**SSD 8699 Redevelopment of Greenwich Hospital (Concept)**

Thank you for your correspondence via Major Project portal (ref: PAE-845) on 22 October 2019, requesting Transport for NSW (TfNSW) to review and comment on the above.

Figure 3 Accessible paths of travel

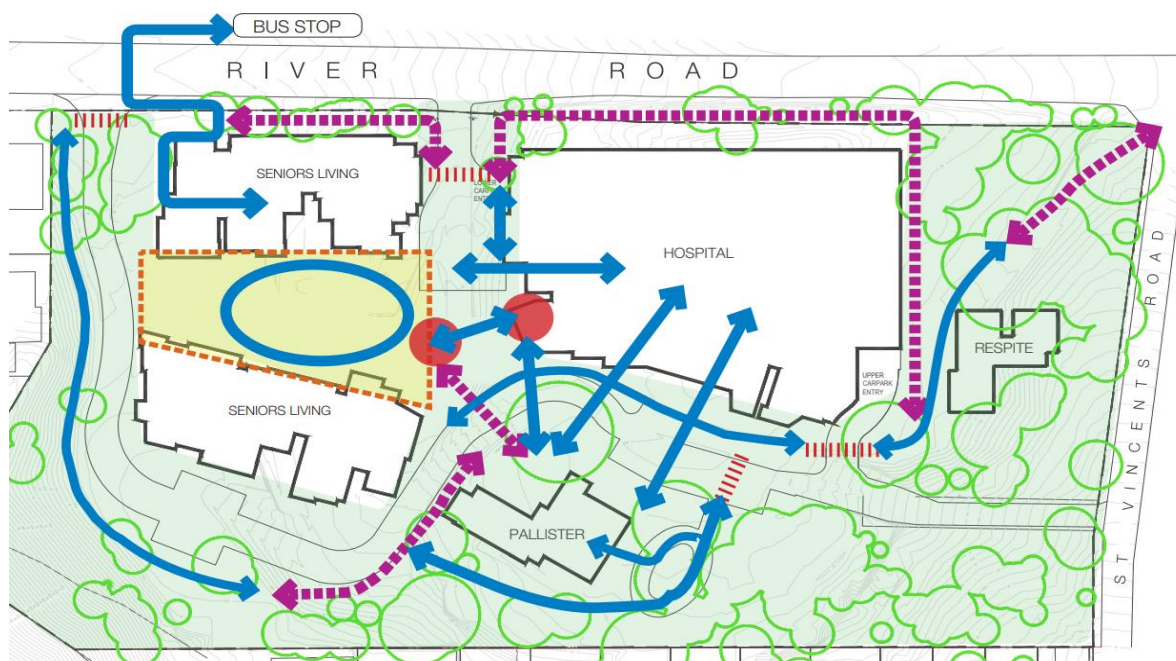
The Response to Submissions (RtS) report states that the bus stops located outside the site's north western boundary are the nearest facilities to be used by the Senior Living residents. The proponent also confirms the preferred route, as presented in Figure 3 of the RtS report is suitable for people with disability accessing between the bus stops and the site. On this note it is recommended that adequate way-finding signage and strategy should be provided to the future residents of the proposed development.
